Heritage Advice

Bicester Heritage: Alterations to Buildings 81, 97, 2.no tank stores, construction of new bin store, and car port – Reference 19/00146/LB

Garry Campion, Senior Conservation Officer

21.2.2019

Project Title		Bicester Heritage	
Drawing Title		Building 81 Existing and Proposed.	
Project Ref.	1680	Drawn	LW
Checked	Date Jan 19	Approved	Scale at A1 1:100
Drawing Number	PL311	Rev

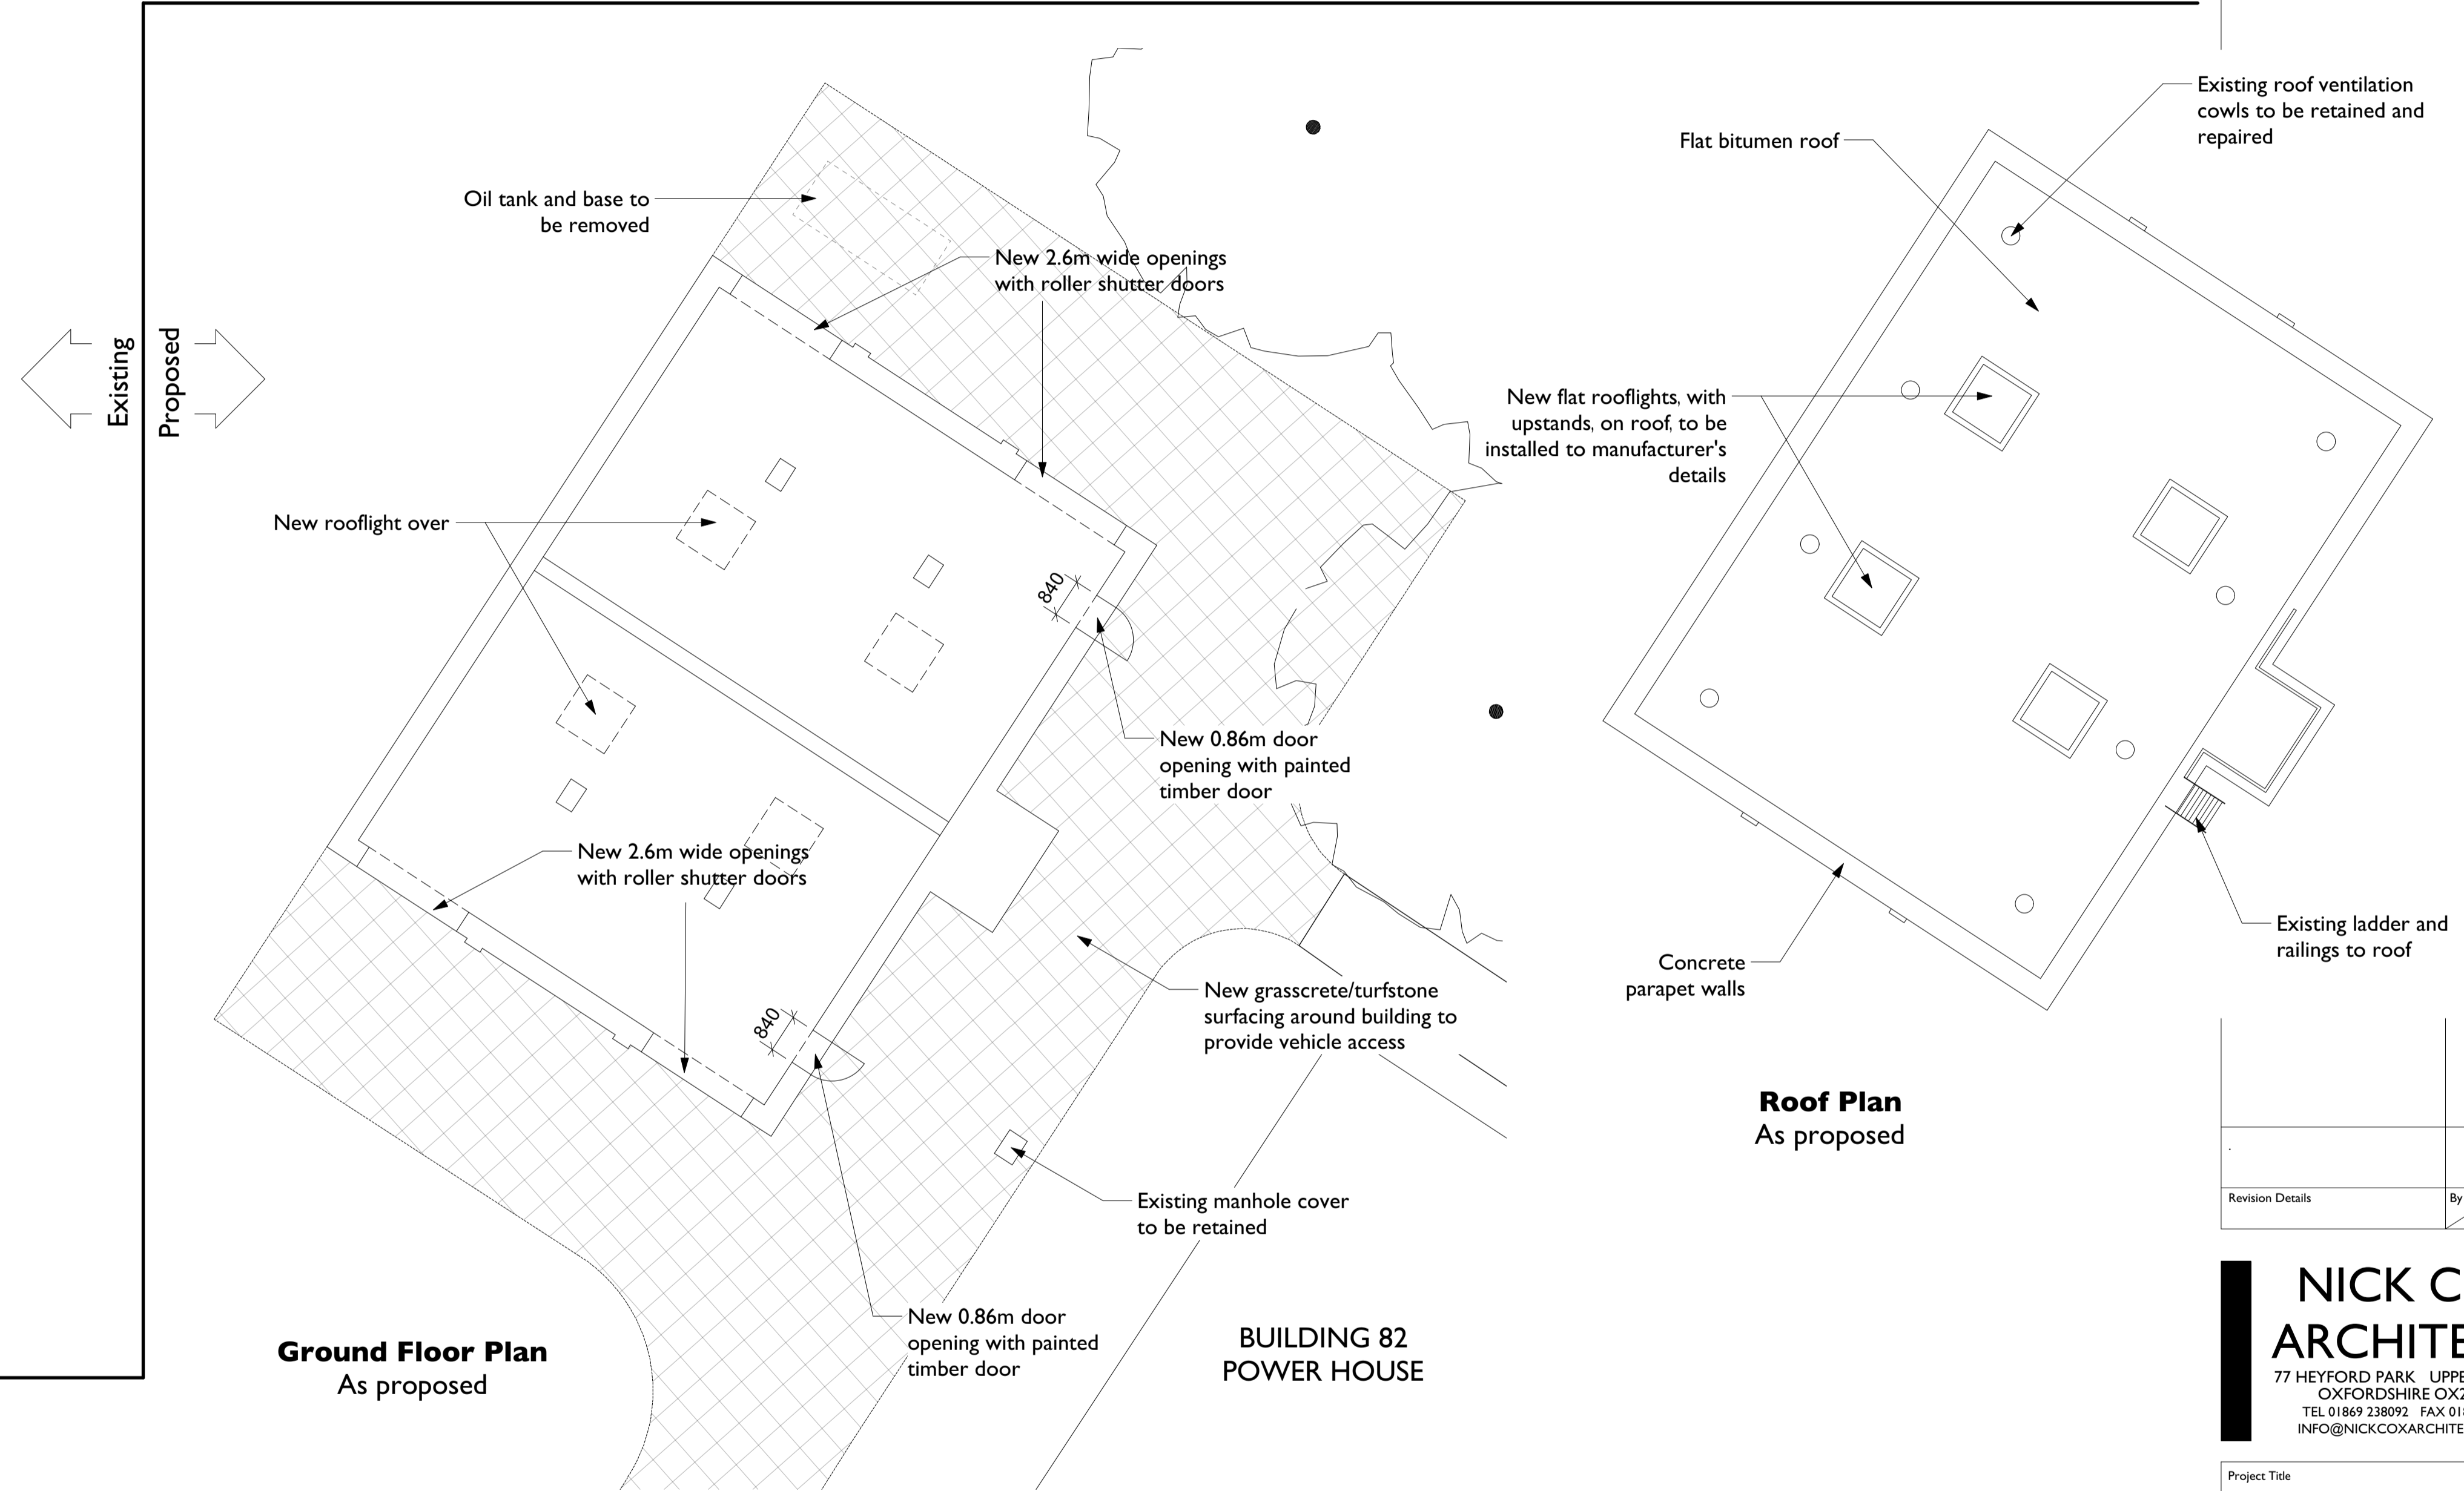
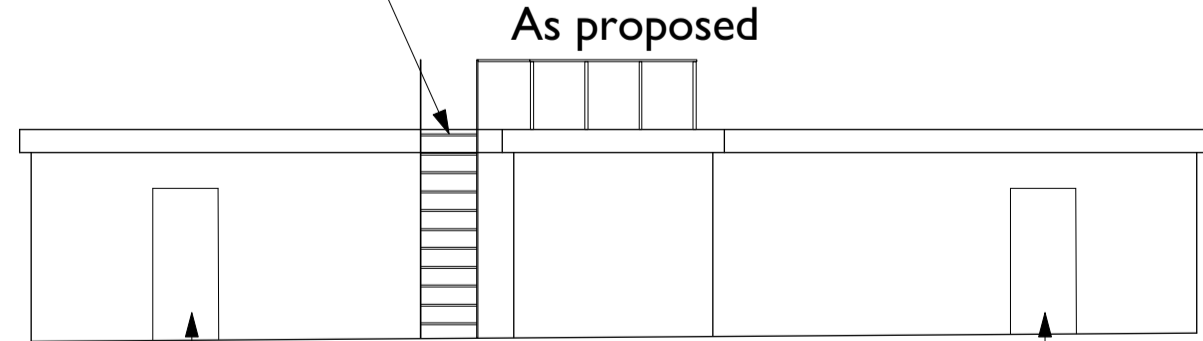
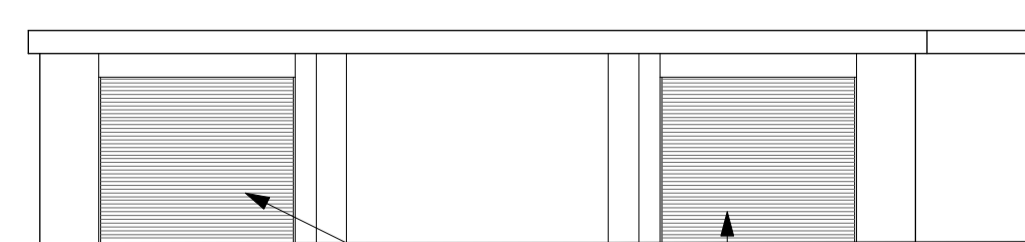
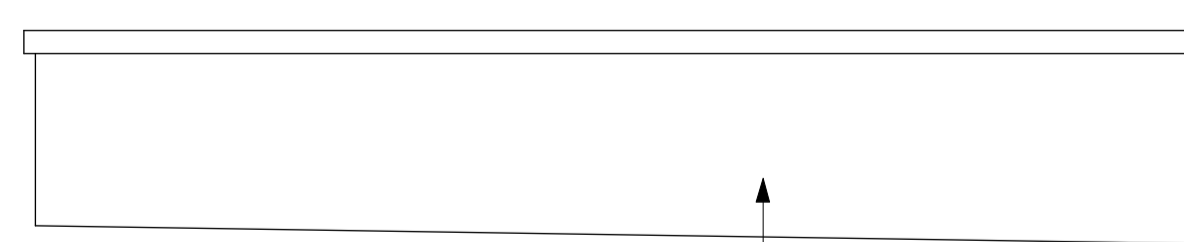
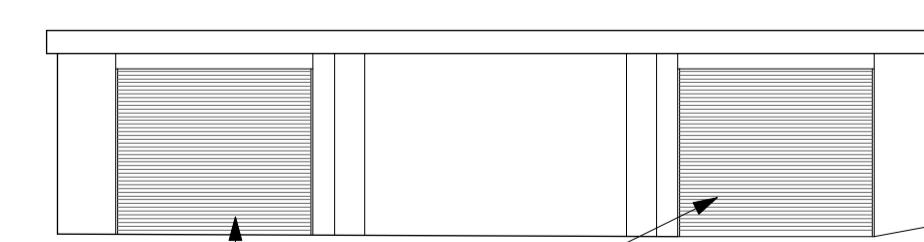
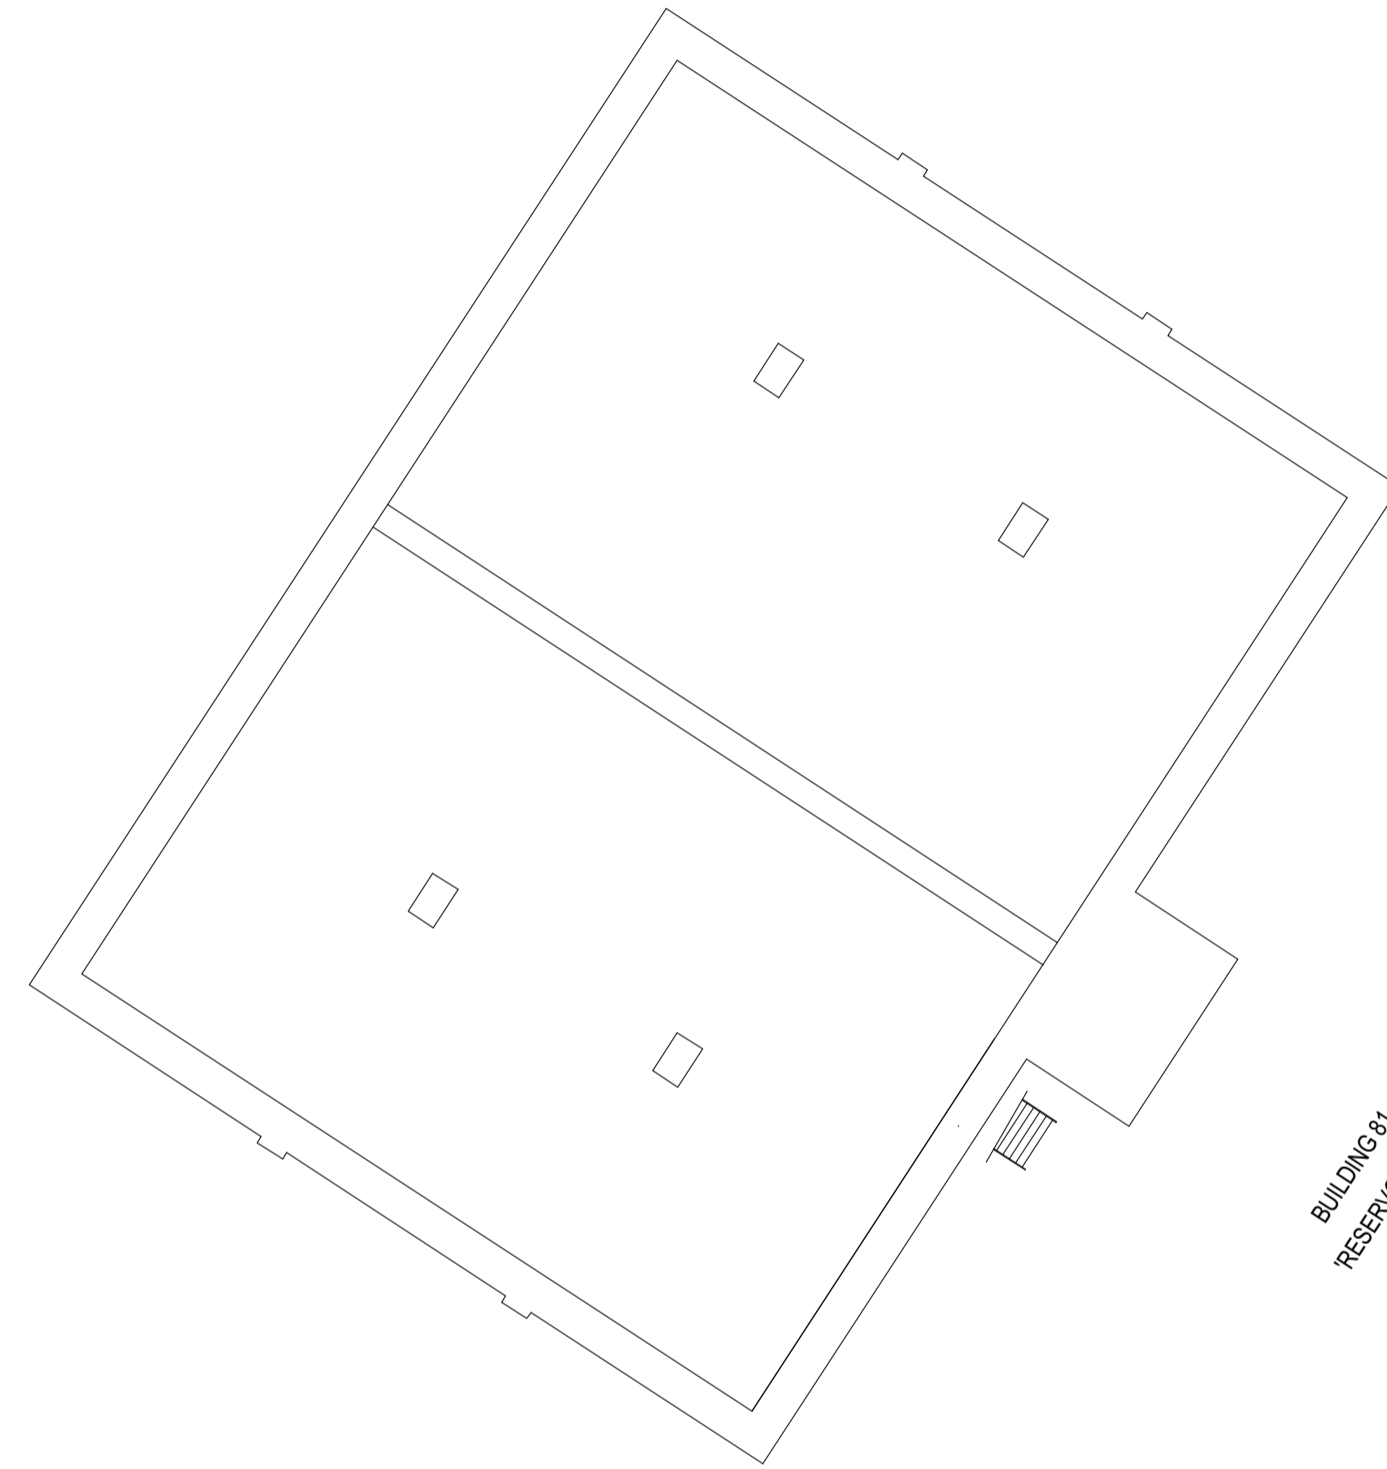
The proposal is to convert the structure into two garage workshop units, formed from the water tank structures. Two roller-shutter doors are proposed to the north and south elevations, with rooflights and additional doors for normal entry. Landscaping around the building to enable new use is also proposed. Currently, Building 81 is surrounded by rough-grass with no road / track providing vehicular access to it.

The proposed re-use is an unusual one, but it has merit. Because of the building's form, materials and construction, options for its re-use are very limited. If the building is to be re-used positively and therefore conserved into the longer term, this is one of the very few potential options without a more dramatic level of remodelling. The proposed door openings will alter its appearance, but the longer elevation facing east, is not much altered. Similarly, rooflights will allow daylight into workshop areas, but will not be visible from the ground. Given these reasons, the proposed re-use is considered to be viable, and is supported. It would also inject activity into this part of the technical site.

Drawing Title  
**Building 81  
 Existing and Proposed Block Plan**

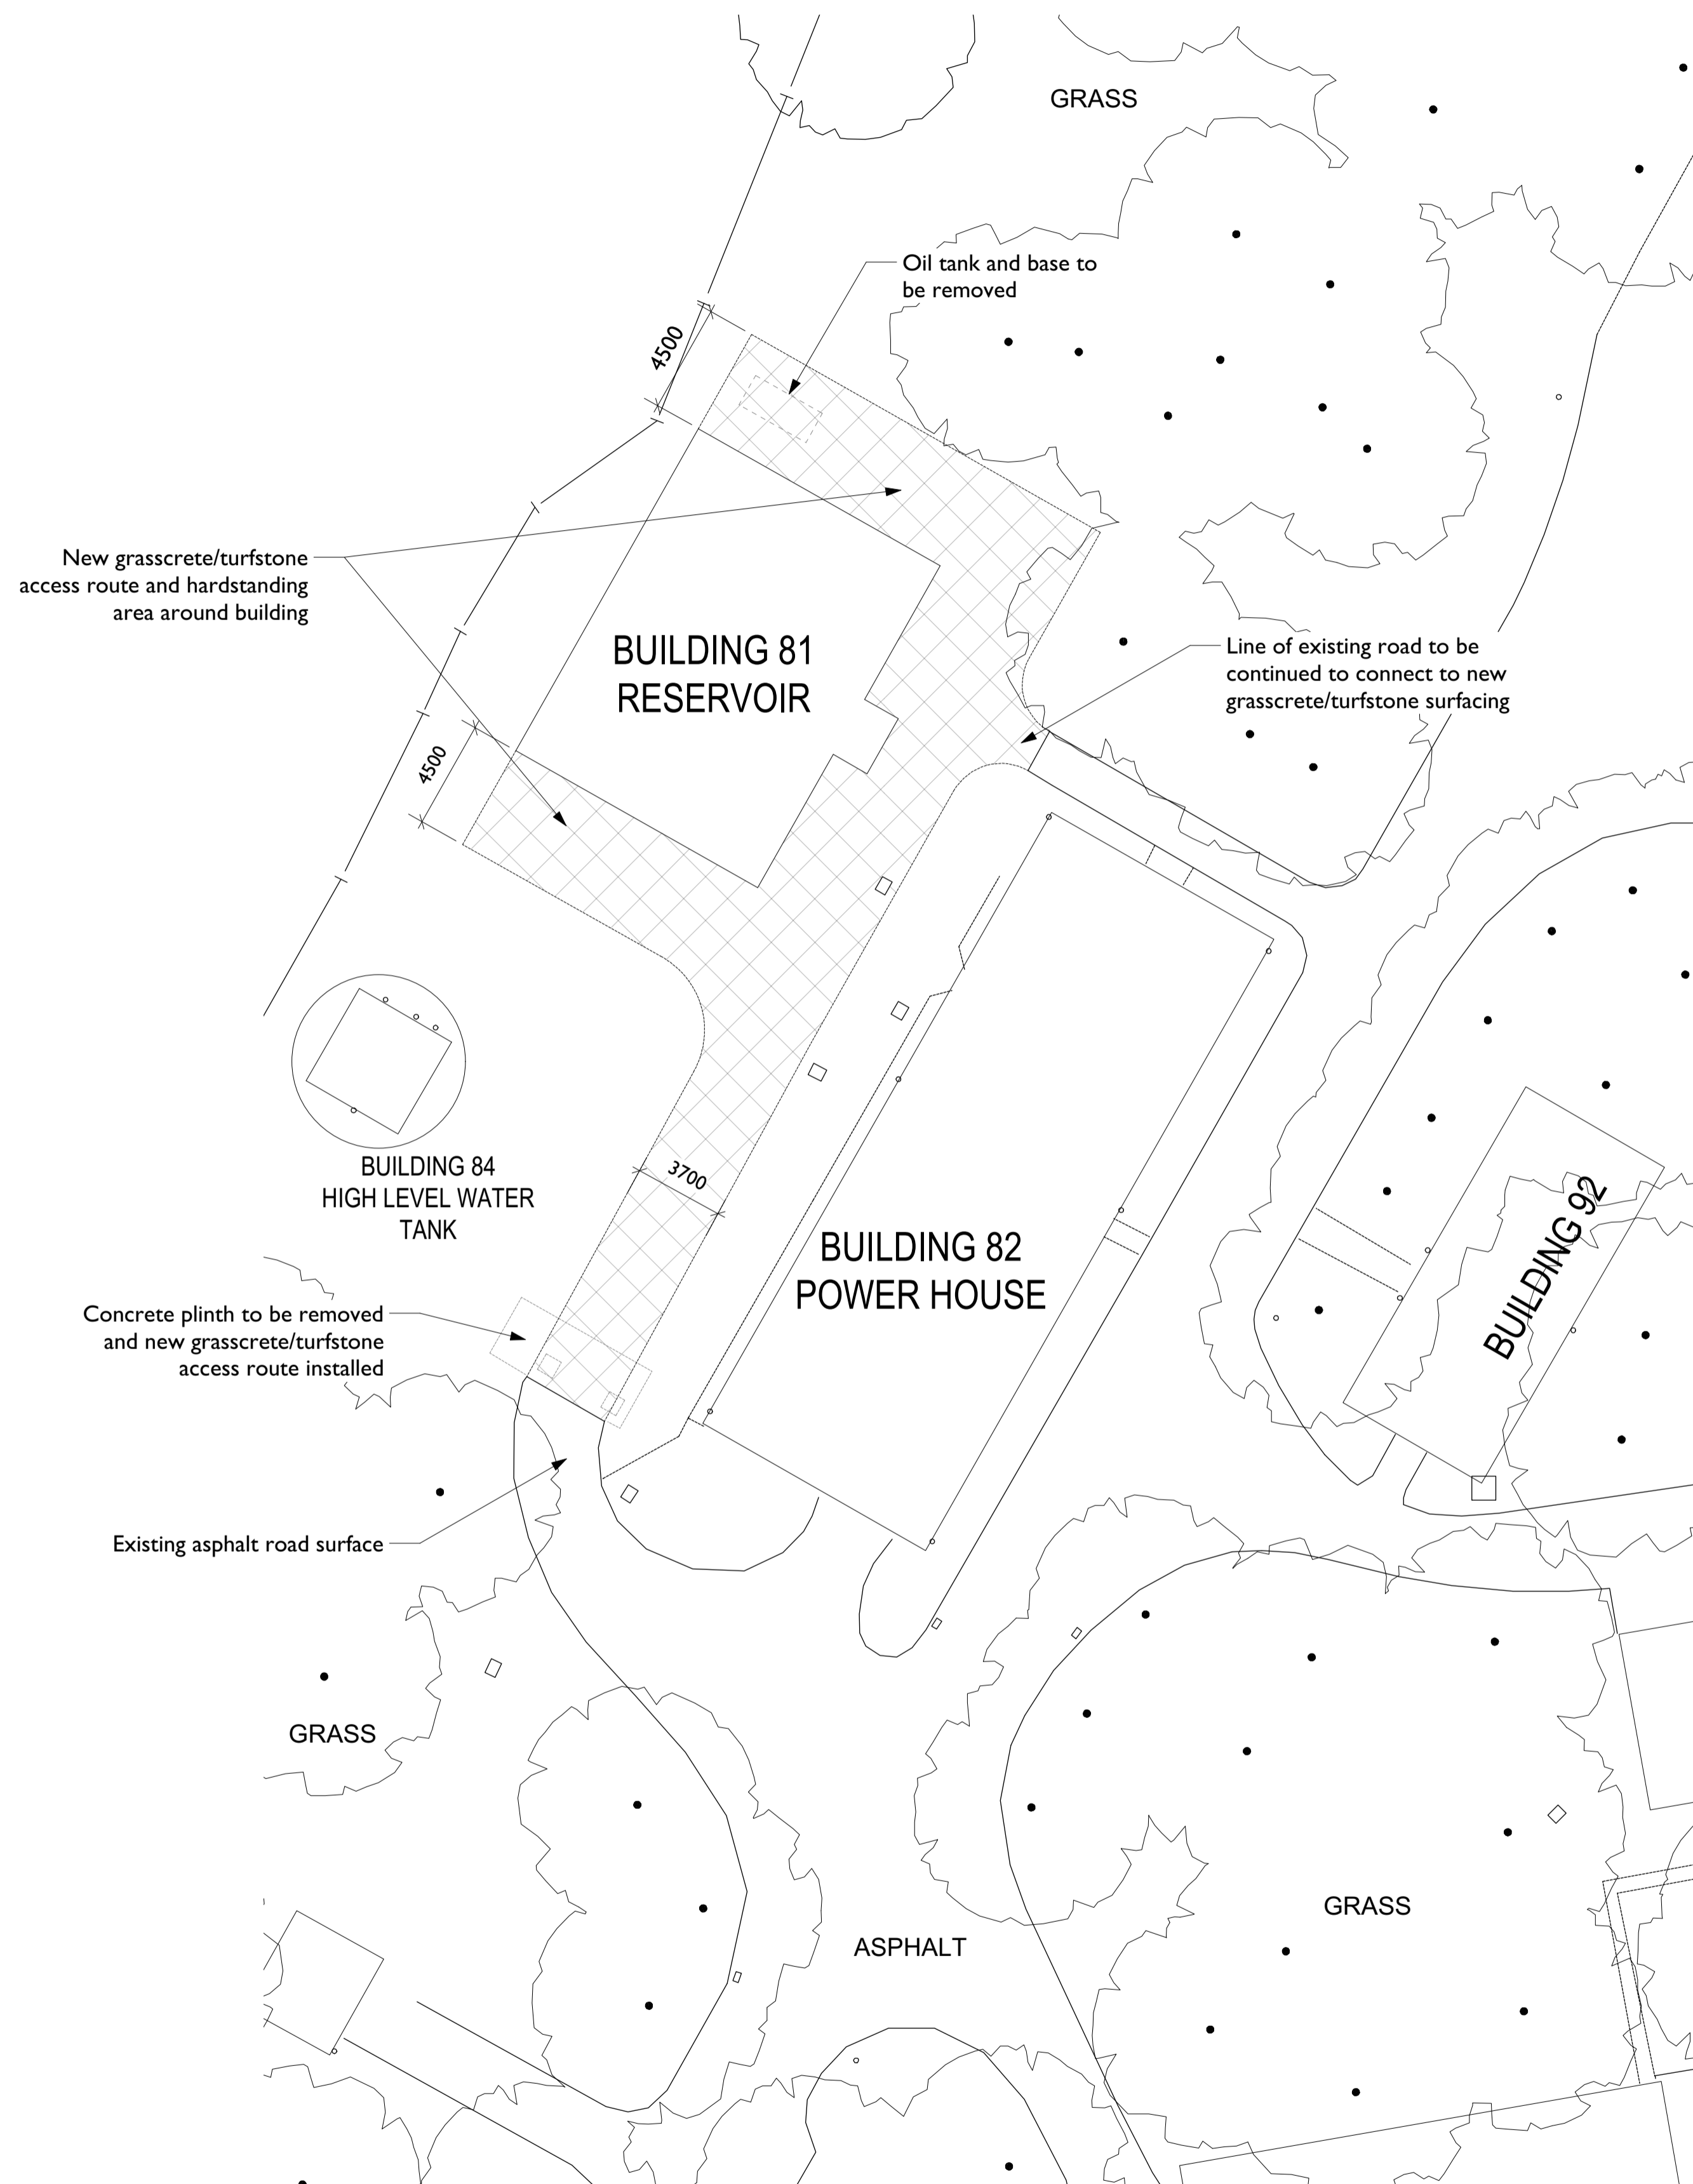
This suggests that an appropriate re-use is potentially possible. Moreover, whilst Building 81 is in quite close proximity to several Listed Buildings, because of intervening screening from adjacent buildings, there is little inter-visibility. This extends to the proposed landscaping to provide vehicular access to the site, which would again be largely hidden from key viewpoints within the technical site. For these reasons it is considered that the proposed re-use would have a limited impact upon the setting of adjacent heritage assets, and the CA itself.
